# FINAL DRAINAGE PLAN

## CREEKSIDE AT LORSON RANCH FILING NO. 1

**SF-19-00X**

**Engineering Review**

LORSON RANCH
CREEKSIDE DEVELOPMENT
EAST FORK JIMMY CAMP CREEK
CHANNEL PLAN AND PROFILE STA 10+00 TO STA 22+00
EL PASO COUNTY, COLORADO

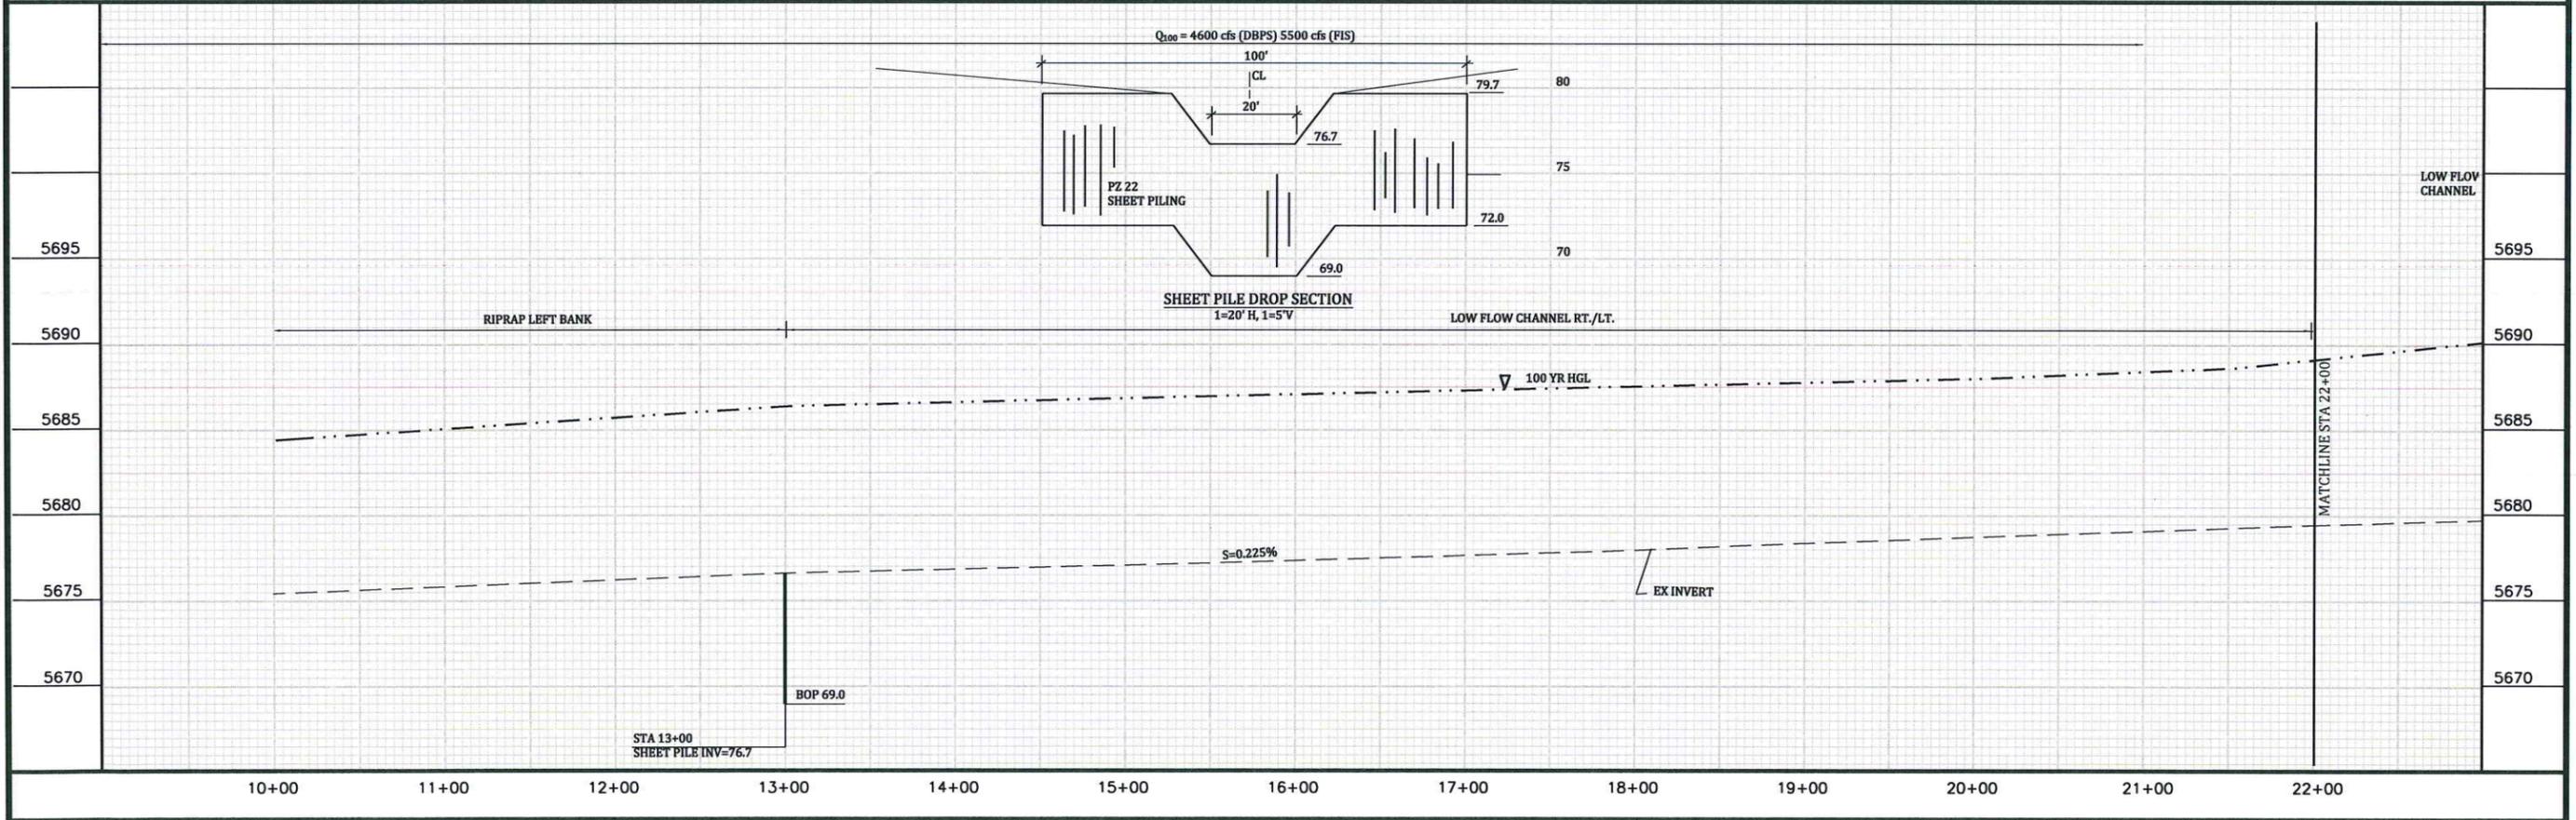
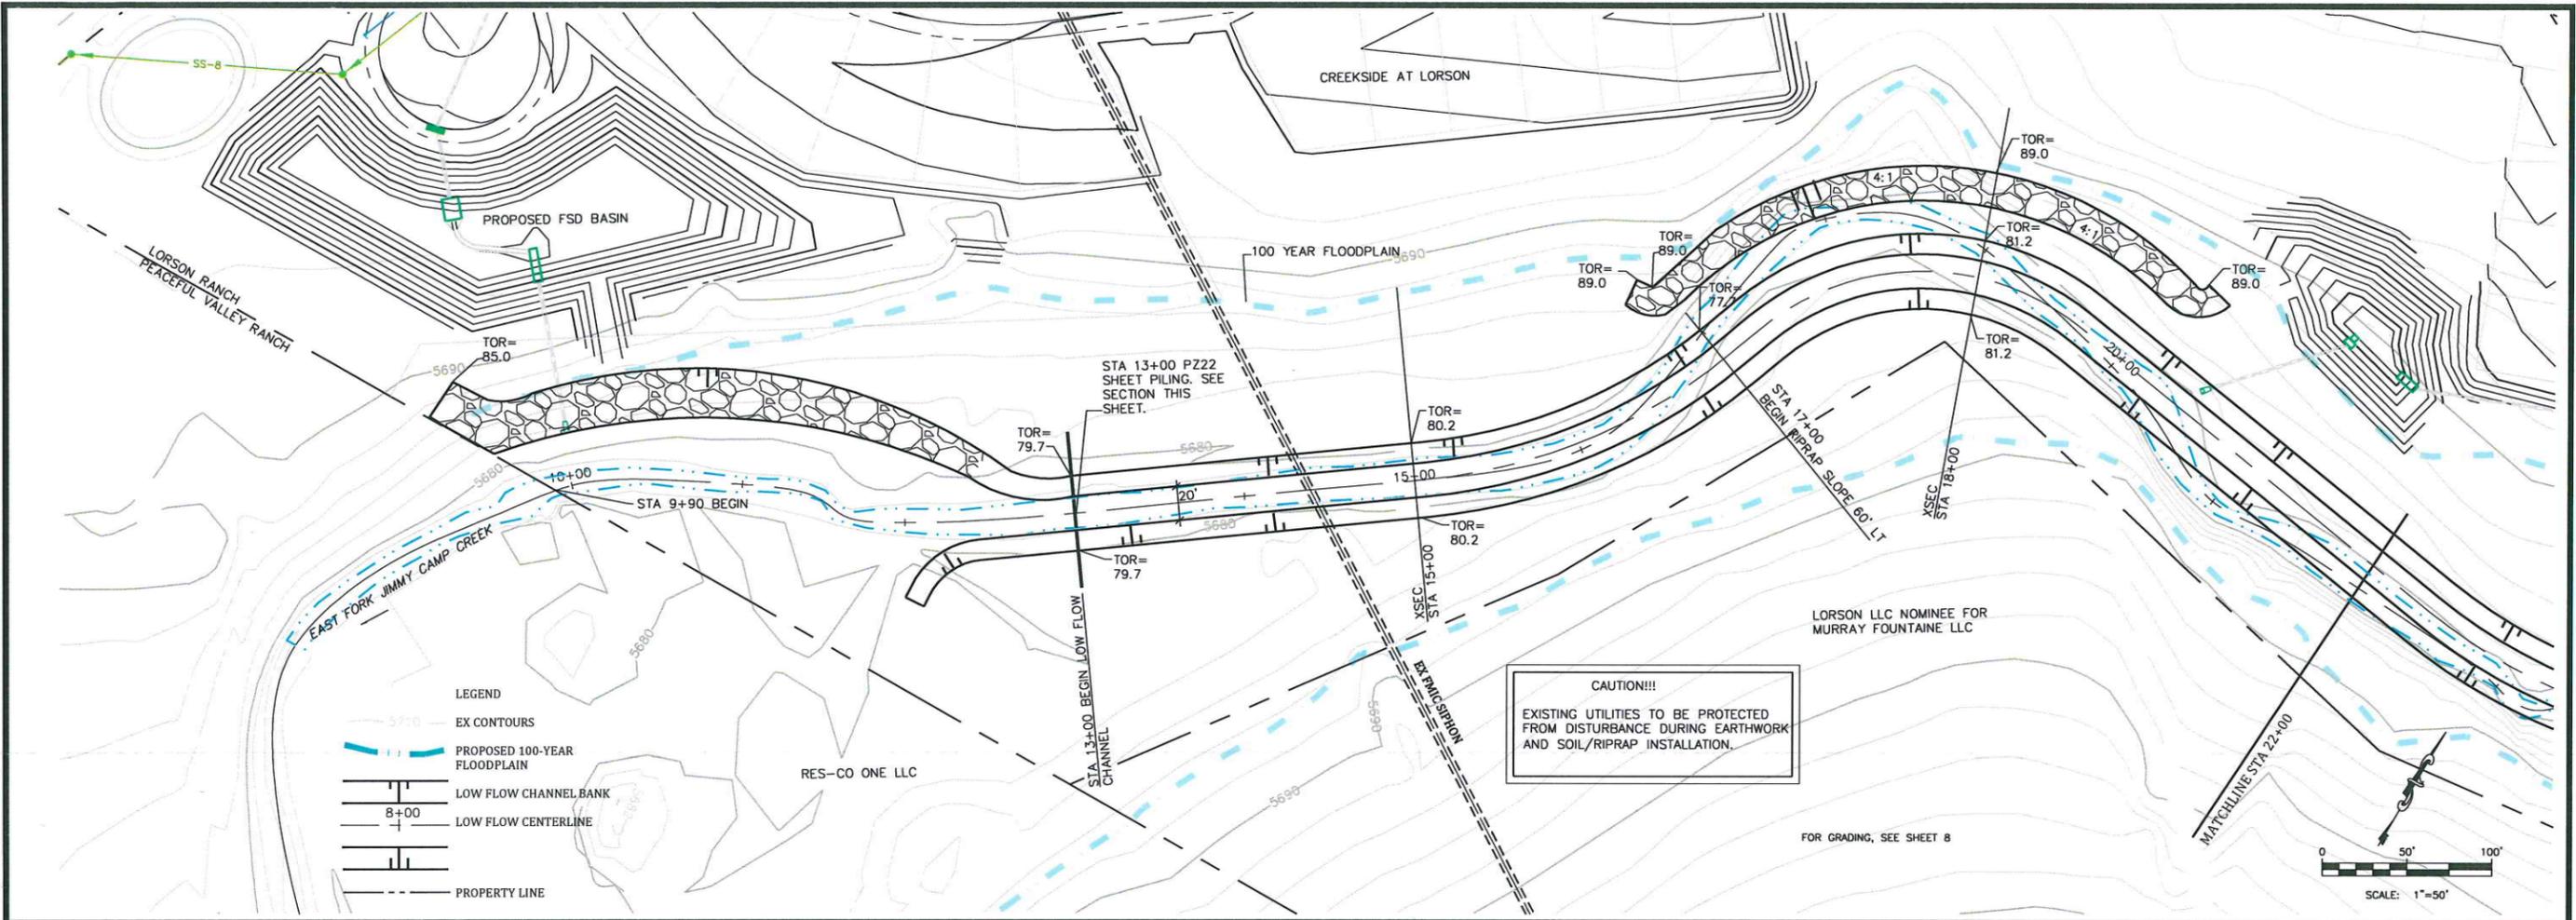
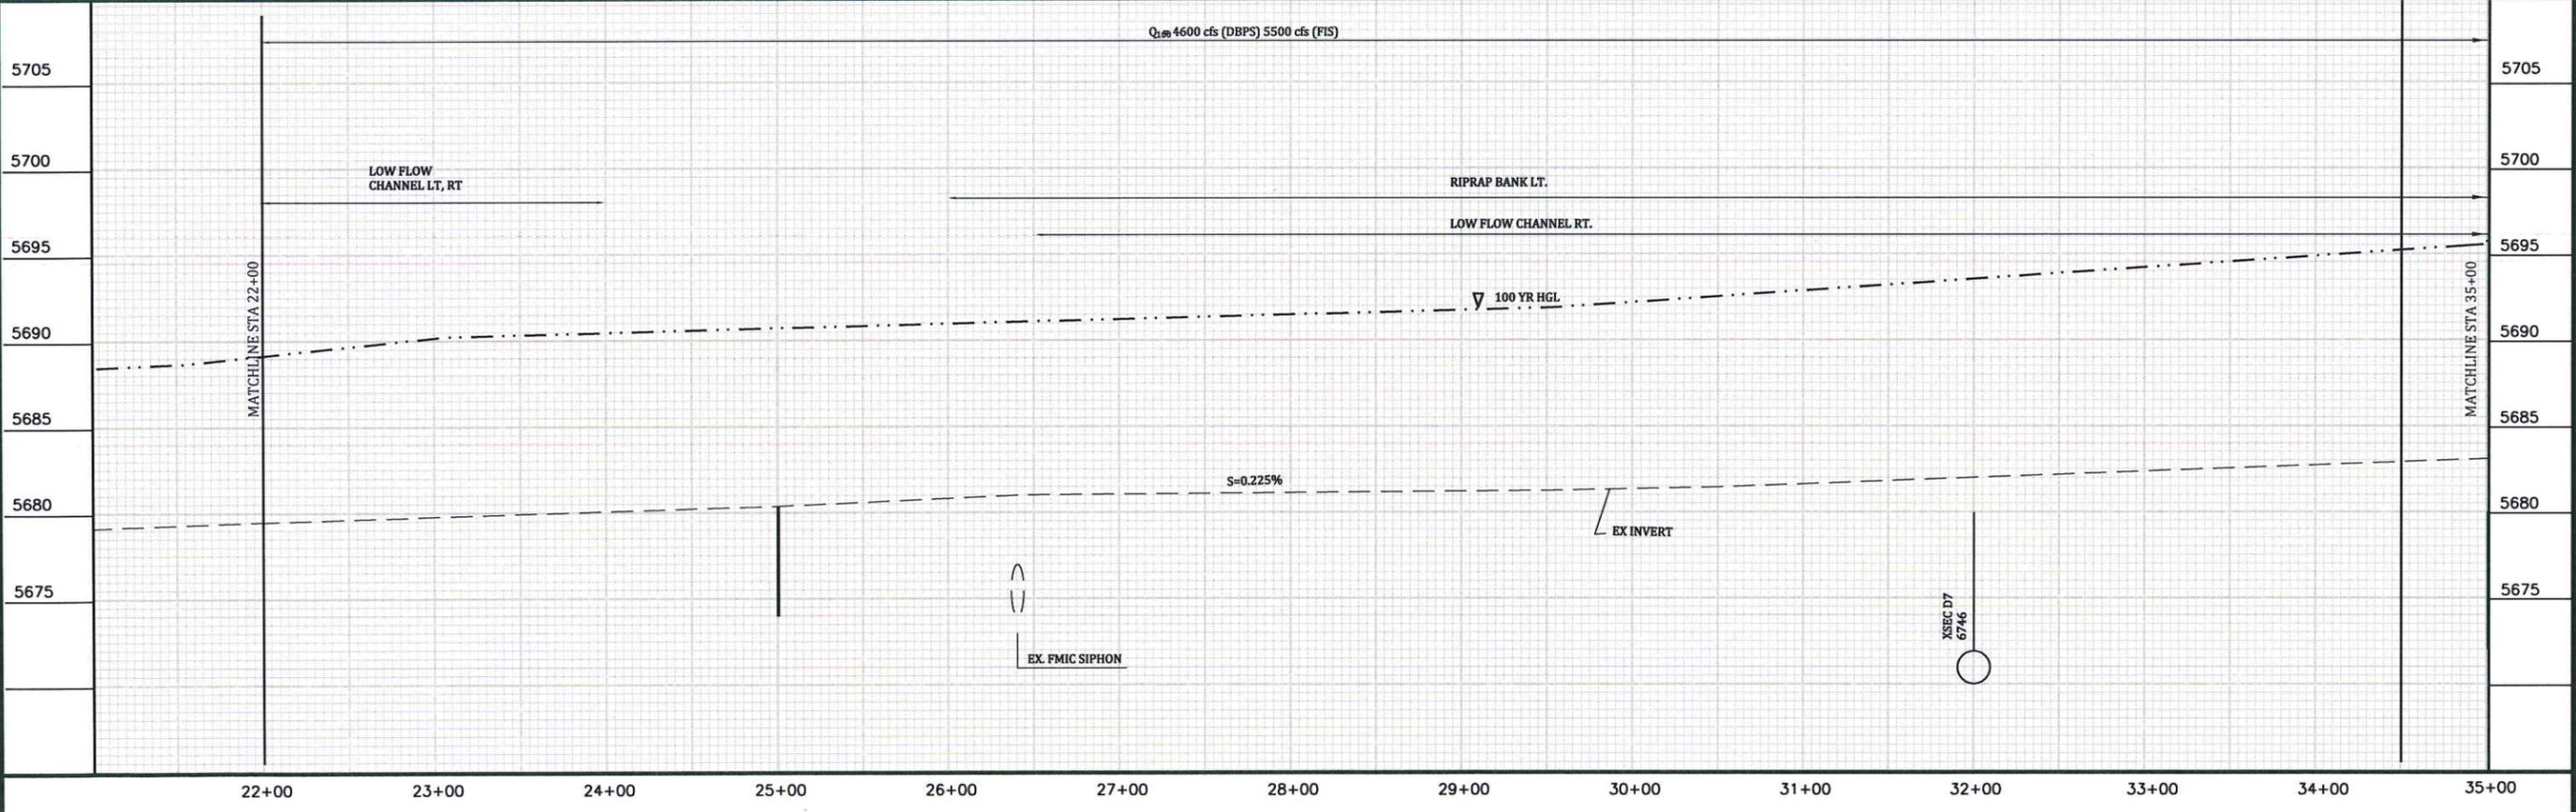
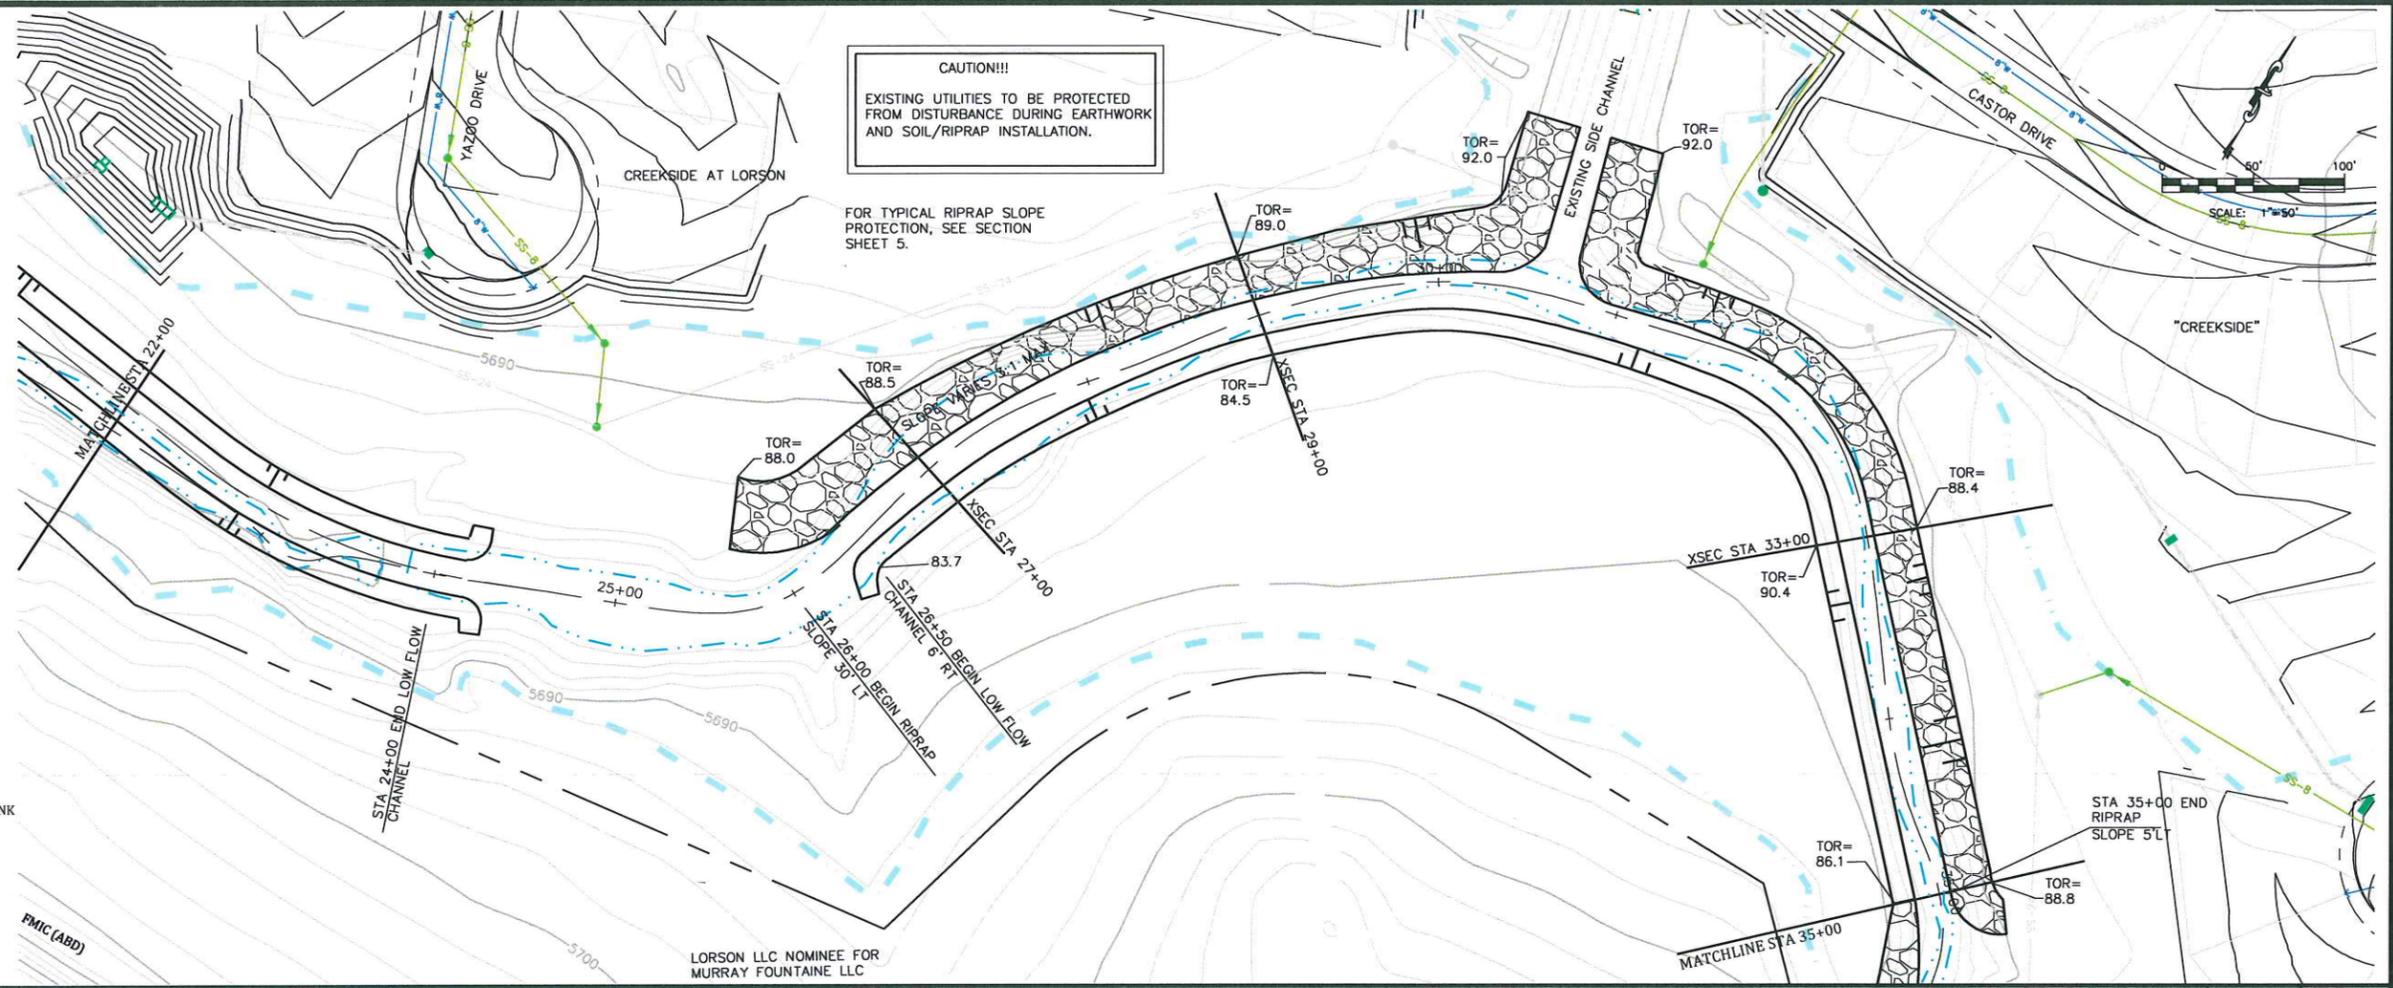
## Address what's being done. Is there a separate channel design report?
